**SHOALHAVEN CITY COUNCIL
ENVIRONMENTAL ASSESSMENT SUBMISSION TO THE NSW DEPARTMENT
OF PLANNING
PART 3A, ENVIRONMENTAL PLANNING & ASSESSMENT ACT, 1979**

MAJOR PROJECT APPLICATION MP 06_0205

**Vincentia District Centre
Modification No 3**

PROPOSAL: Proposed MP06_0205 VDC Stage 1 - Modification No 3 being modification to the VDC Stage 1 approval by delivery of the VDC in stages with Stage 1 now being proposed as Stage 1A and Stage 1B and the future Stage 2 as shown in Mod 2 application

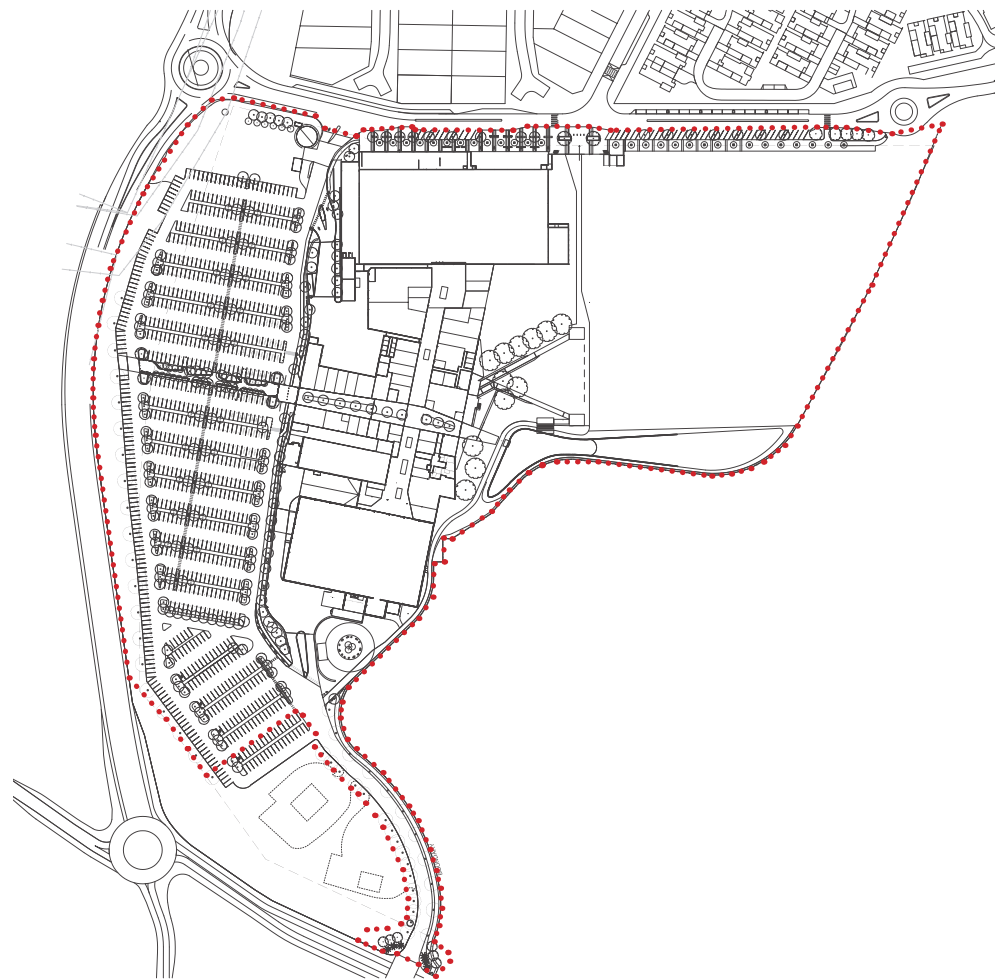
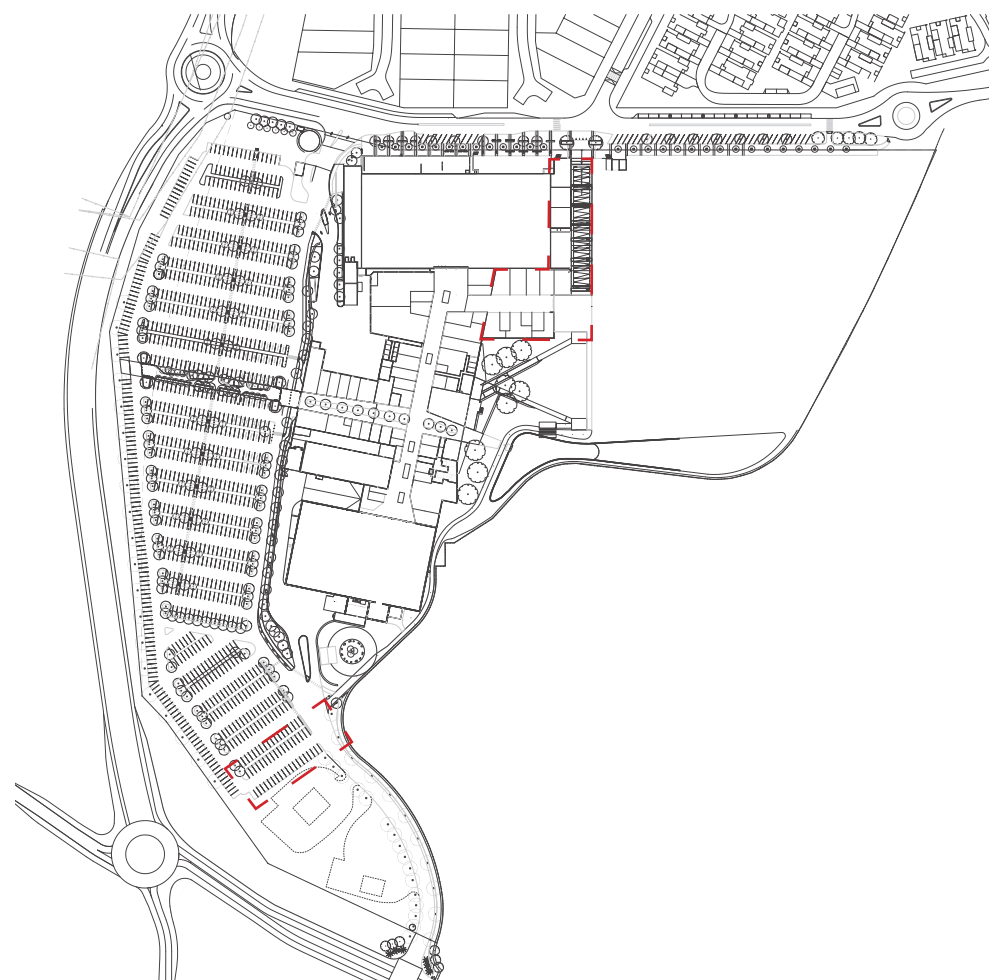
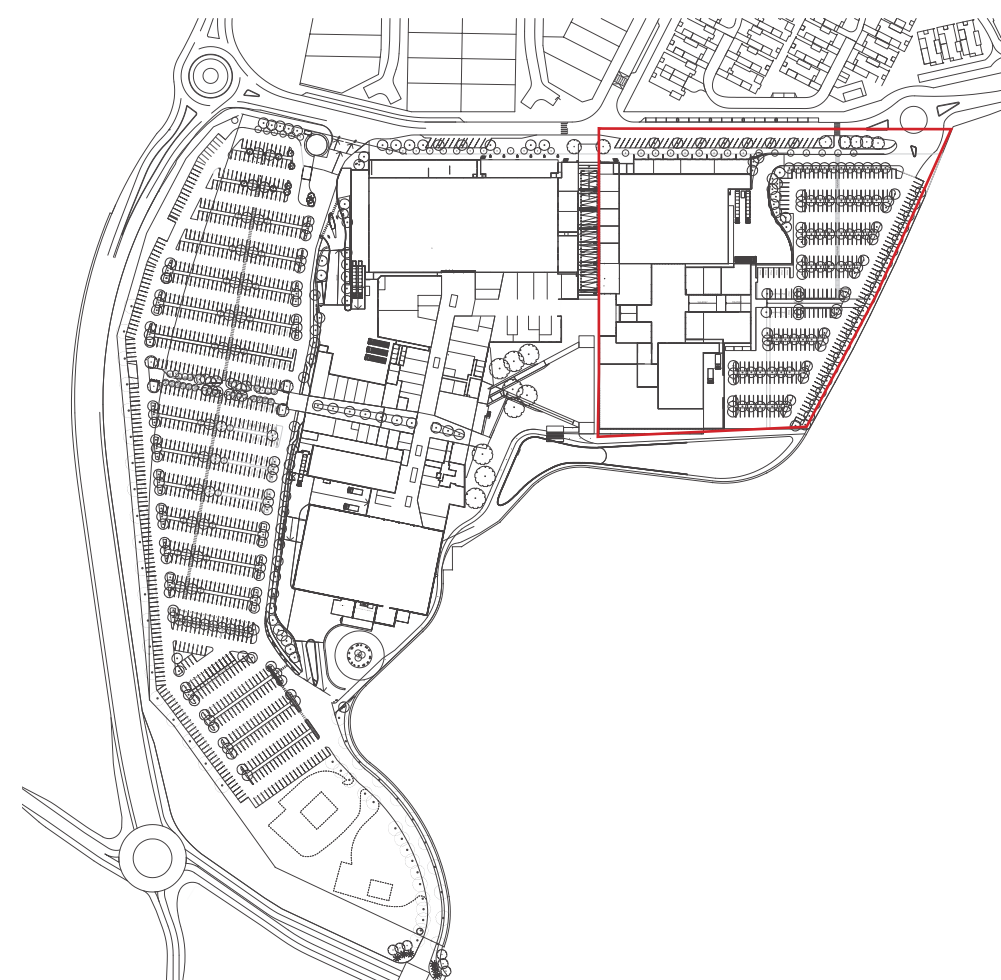
There is conflict between Site Image Landscape Plan LA01-D and the Rice Daubney Phasing Plan DA0103-V in the placement of the Stage 1B works. This should be clarified to identify the appropriate plan which the approval will be based upon.

DRAWING TITLE			
CIVILWORKS KERBS AND RETAINING			
Project No.	Com No.	Drawing No.	REV
104016	46	46870	P0

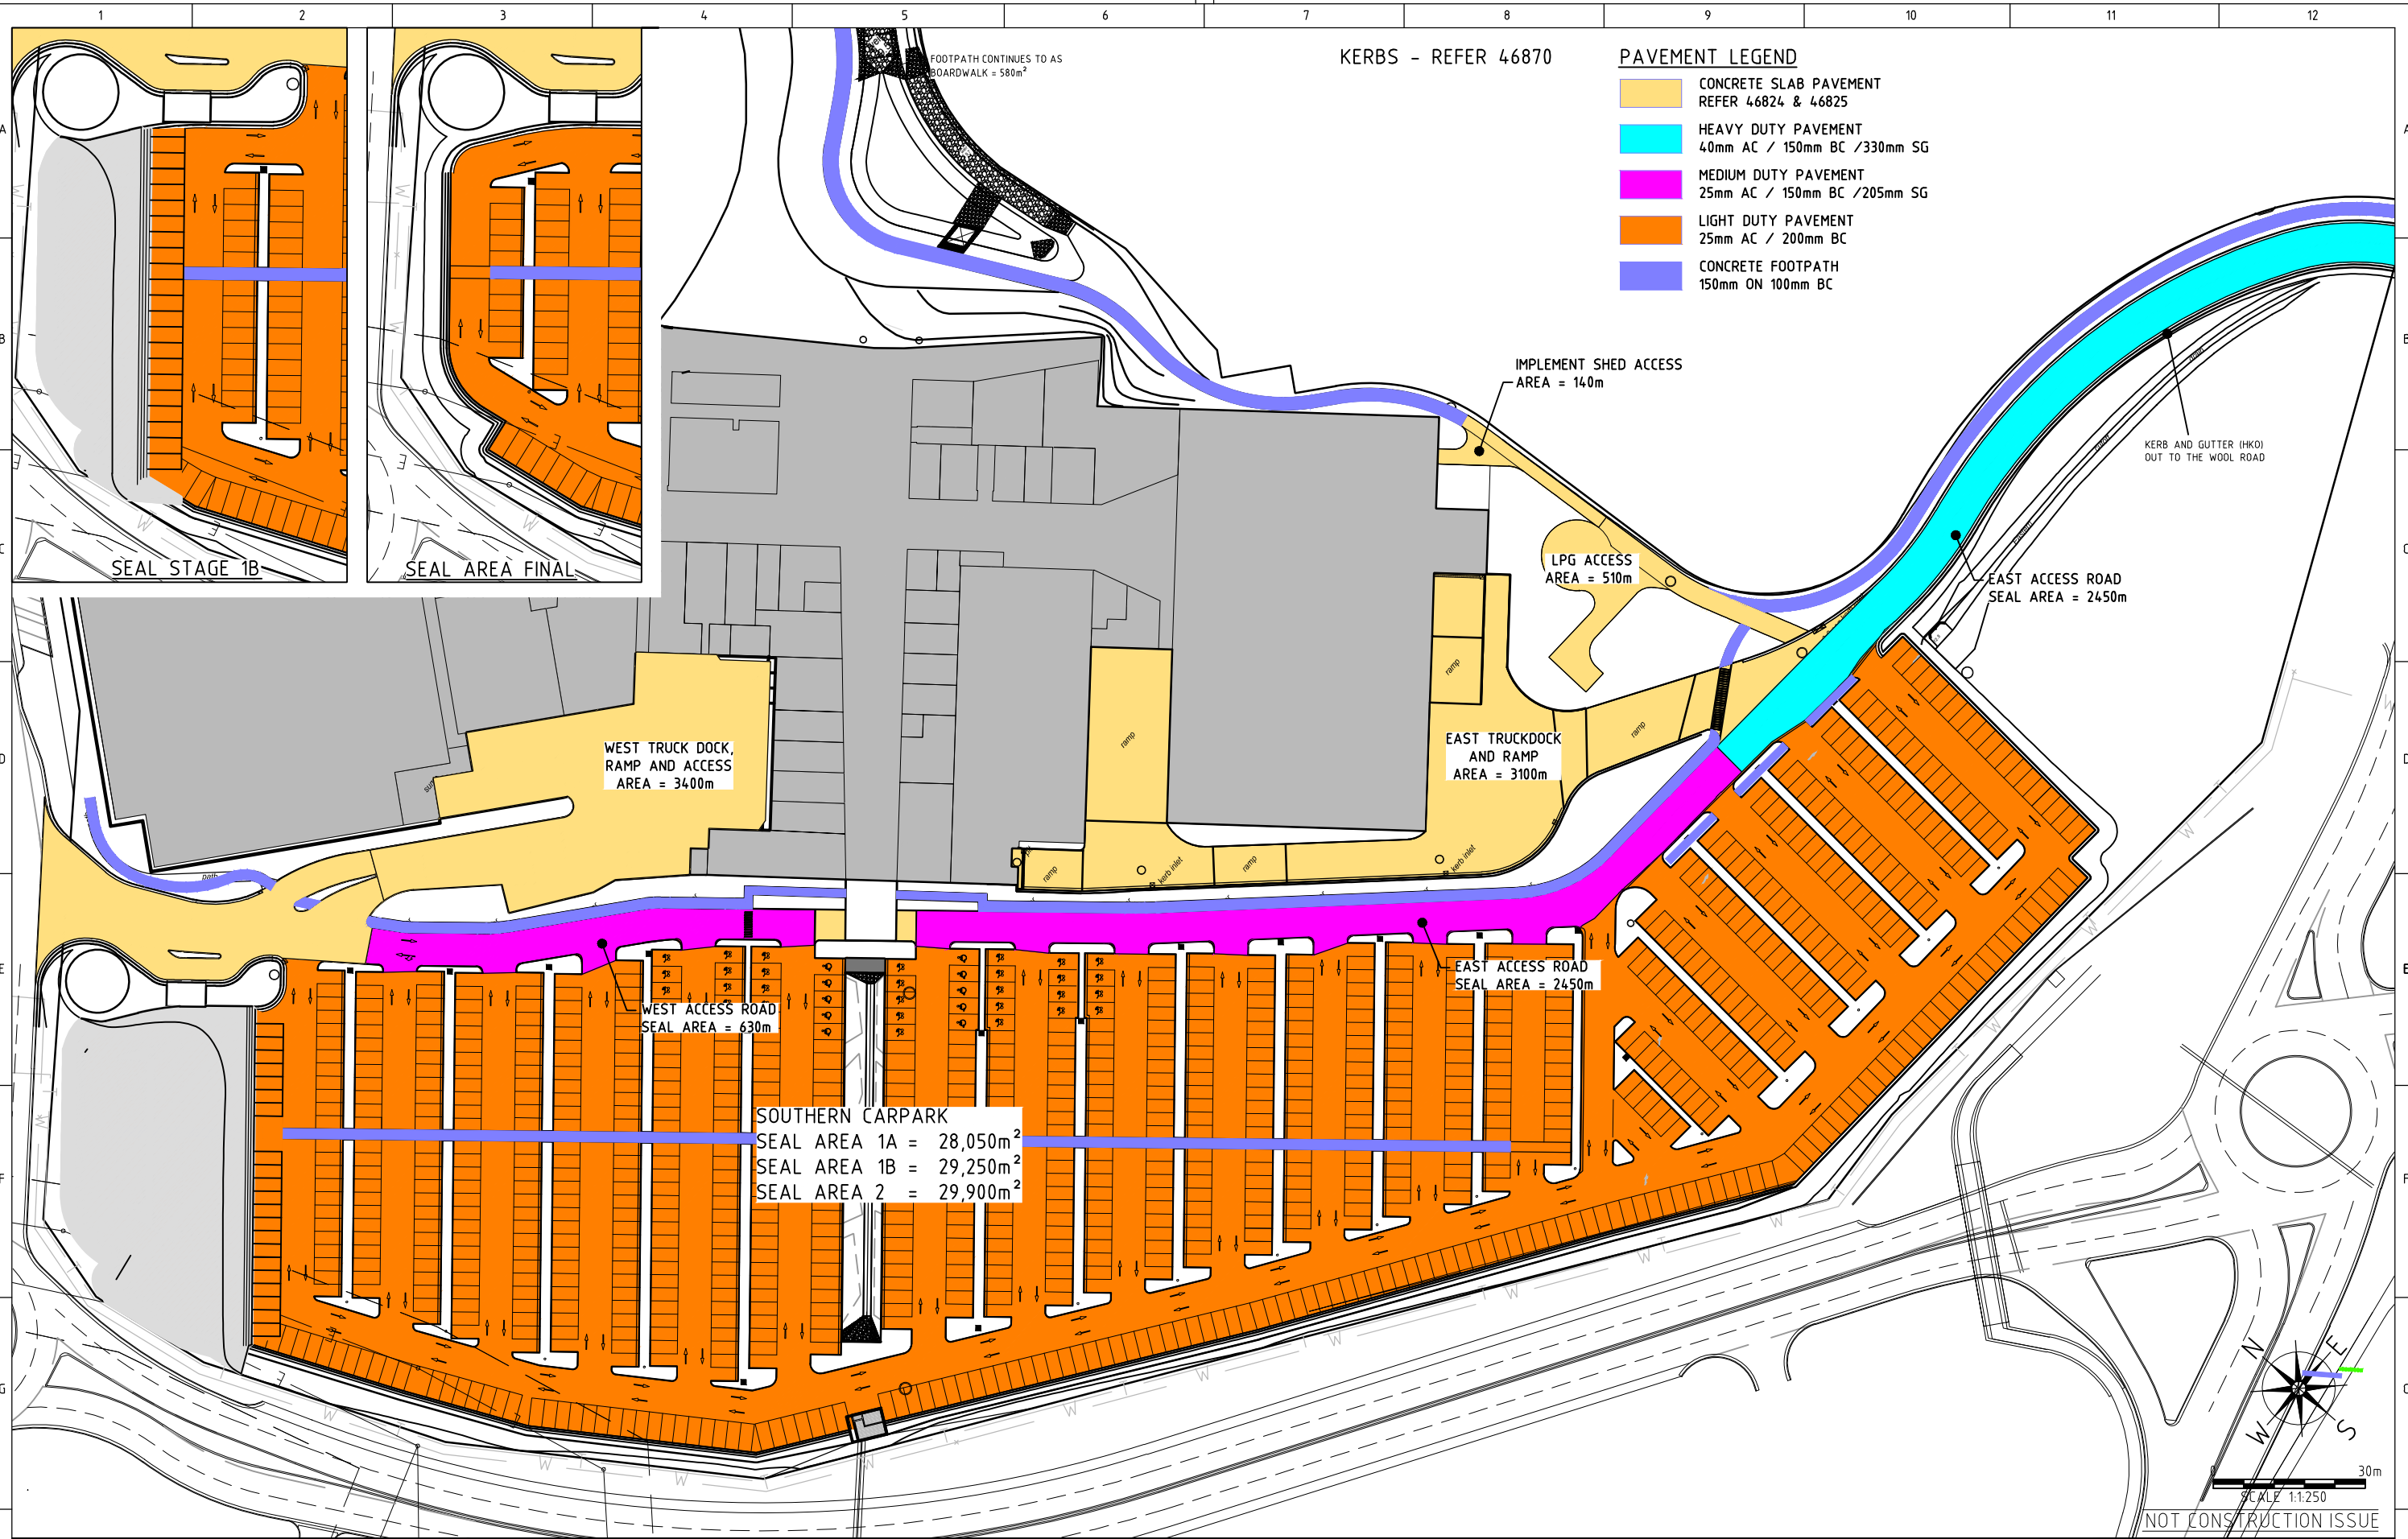
The Mod 3 application includes in Appendix D the civil drawings. Drawing 46863-PO, 46863-PO, 46870-PO relate to the area of the long vehicle car park. The latter drawing shows a kerb that will not permit "drive-through" use of the spaces.

The proponent should correct this matter in conjunction with the final car parking layout that includes provisions for long vehicle car parking.
